CITY OF PORTLAND  
 FIRE PREVENTION BUREAU  
 380 Congress Street, Portland, Maine 04101  
 fireprevention@portlandmaine.gov  
 (207) 874-8400

**NOTICE OF VIOLATION AND ORDER TO CORRECT**

<b>Responsible Party 1:</b> Gervais Steve 44 Park Ave South Portland, ME 04106		<b>Responsible Party 2:</b> Alexandra Rapaport 478 Central Park West #7A New York, NY 10025
<b>Location</b> 61 WILSON ST	<b>CBL</b> 003 M008001	<b>Inspection Date</b> 4/18/2017
<b>Inspector</b> Justin Bragdon	<b>Inspection Type</b> FP Routine Inspection	<b>Status</b> Failed

**A1.0**  
DRAWING NO.

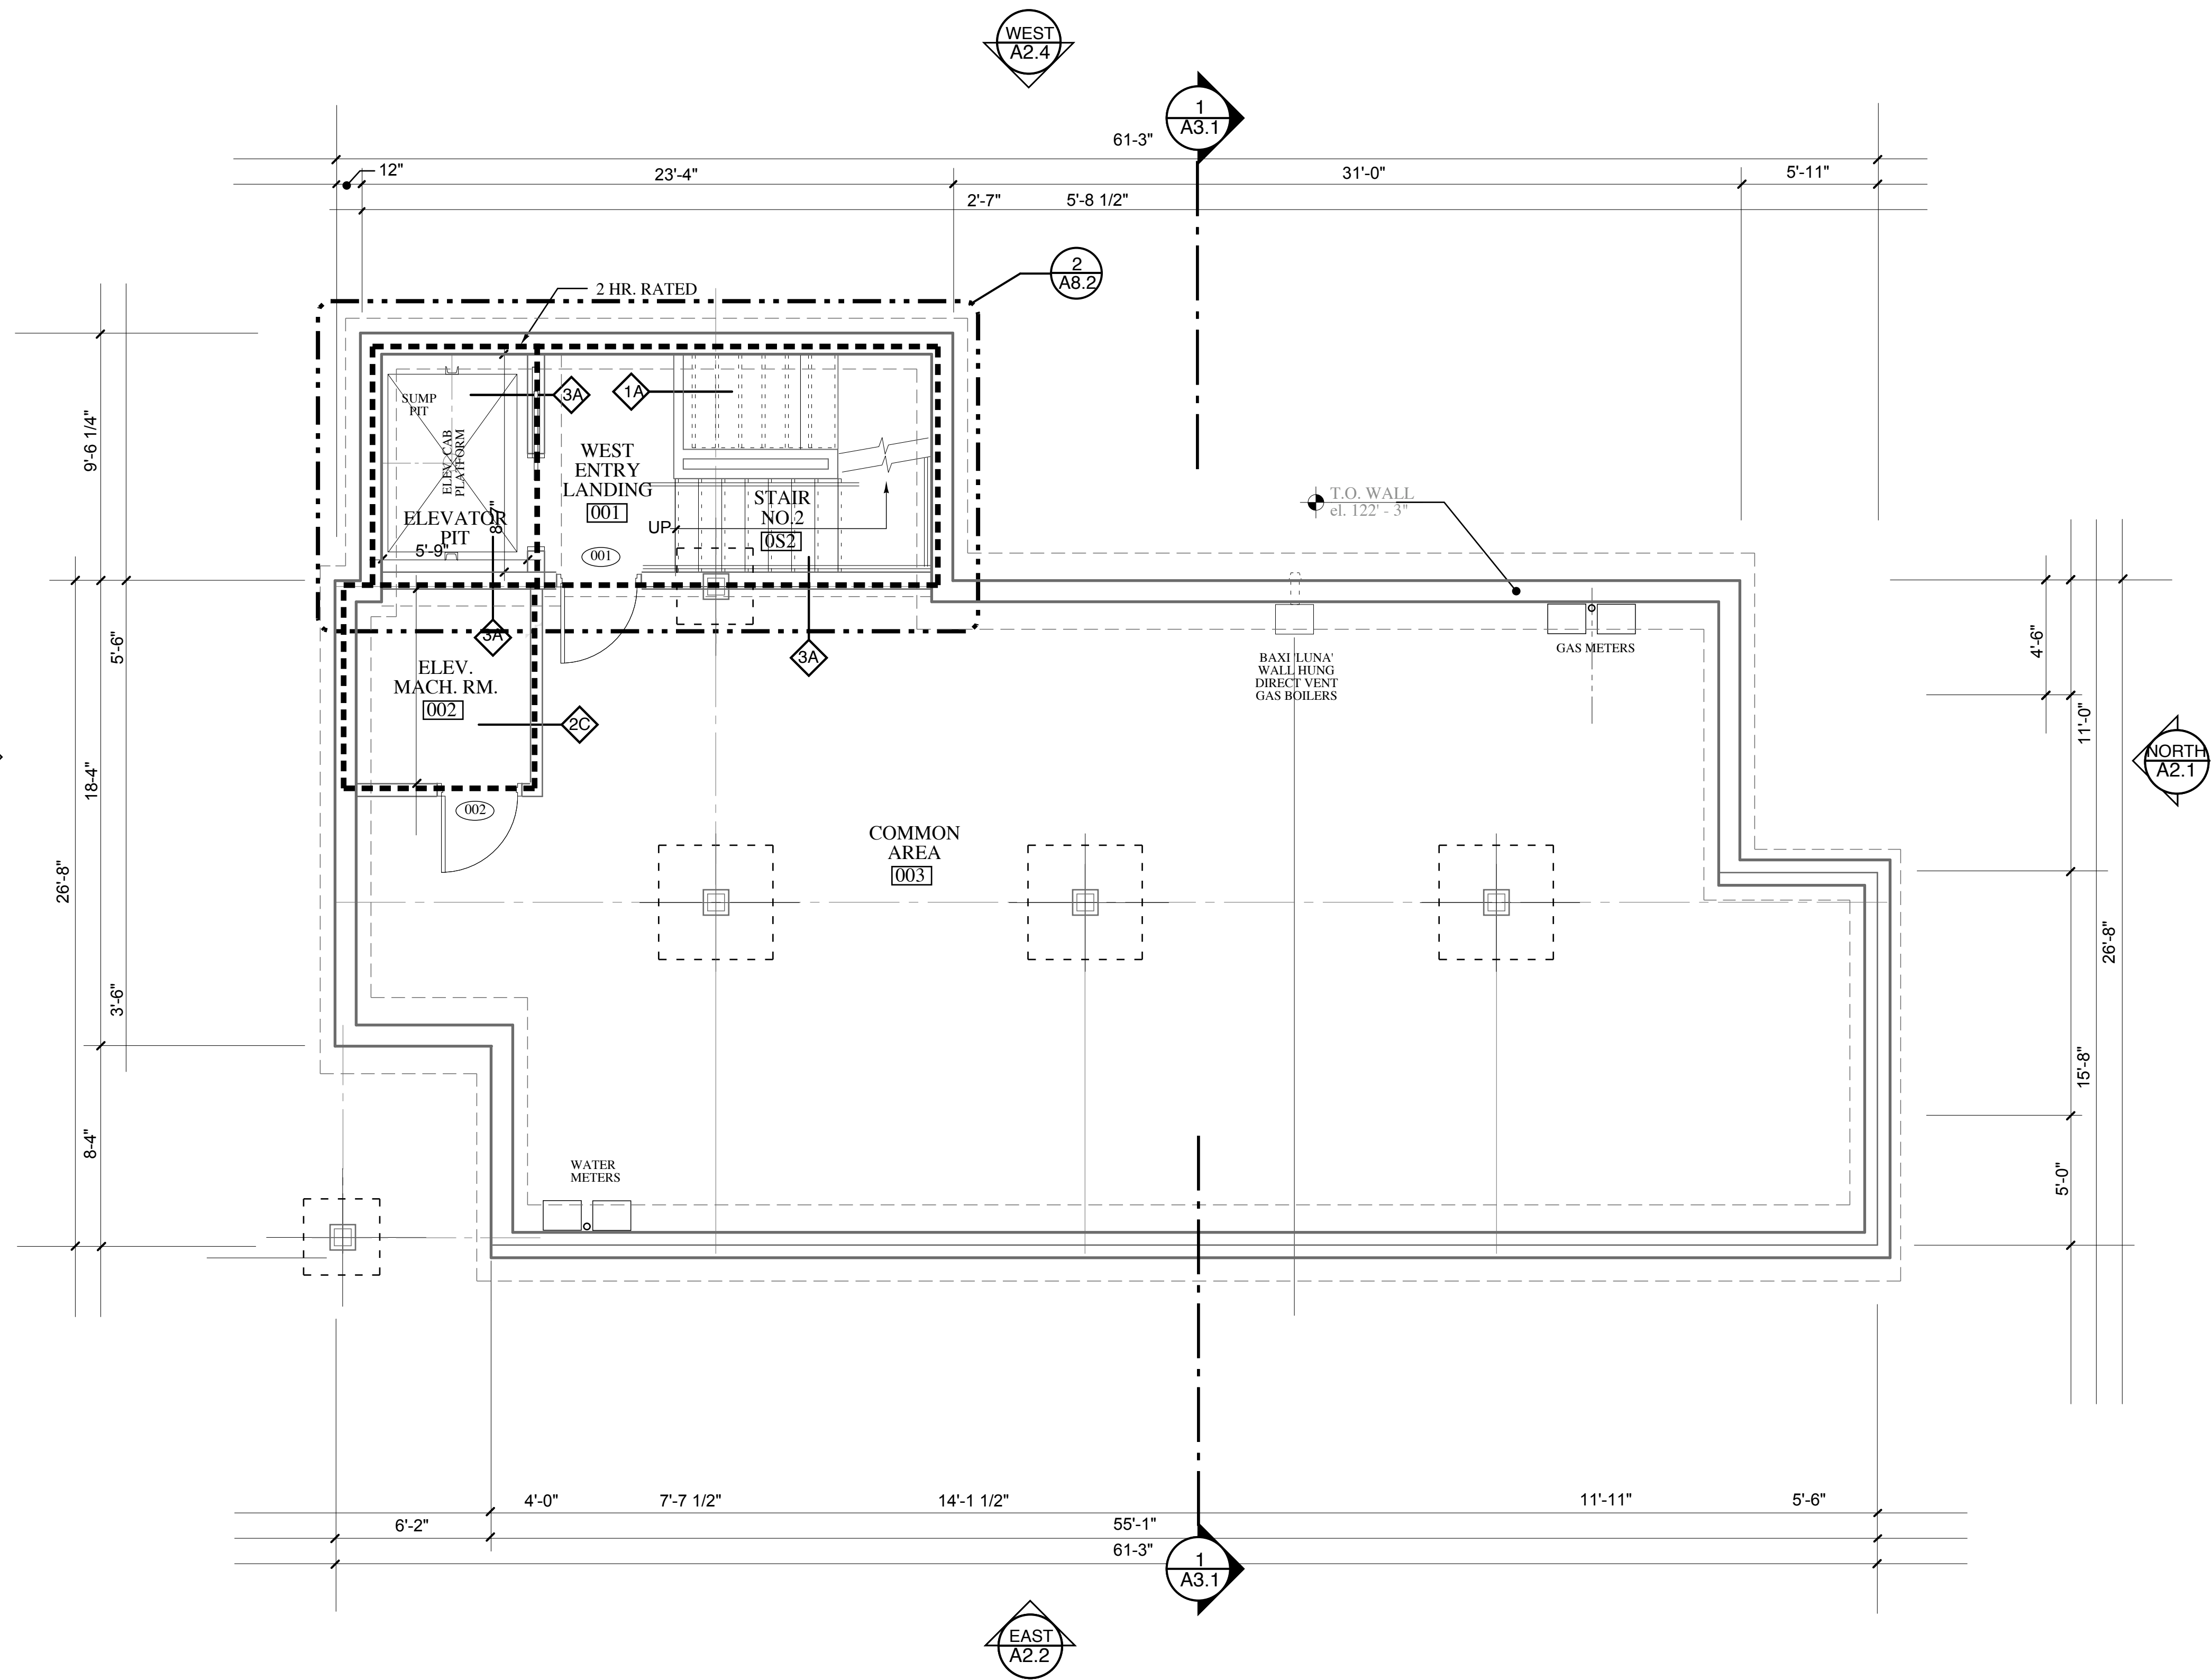
Violation	Proposed Date of Completion
<p><b>NFPA 80- ANNEX D.4 1-HOUR FIRE DOORS ASSEMBLIES REQ;</b> Listings are provided for floor fire door assemblies that are installed in fire-rated floor-ceiling or roof-ceiling assemblies that have been tested in accordance with the methods described in NFPA 288. The listing indicates the fire-rated assembly and the hourly rating (3 hours, 2 hours, 1.5 hours, 1 hour, .75 hours) for which the door can be permitted to be used so that access to the space above the ceiling or to the floor above can be provided without adversely affecting the fire resistance rating of the entire assembly. The listing provides limitations on the maximum size of an individual door opening and the total area of all door openings permitted for each 100 square feet of floor or ceiling.</p> <p>Fire doors are required for each basement door and both doors to the second floor apartments.</p>	8/01/2017

Violation	Proposed Date of Completion
<b>NFPA 101- 22.3.1 HOLE IN FLOOR NEEDS REPAIR;</b> Any vertical opening shall be required in accordance with section 8.6. In the basement there is a hole in the subflooring that exposes the 1st floor bathroom shower plumbing. This needs to be enclosed with approved fire rated materials	
<b>FINAL DATE OF COMPLETED VIOLATION(S)</b>	8 / 1 / 17
<b>FIRE PREVENTION BUREAU RE-INSPECTION OF COMPLETED VIOLATION(S)</b>
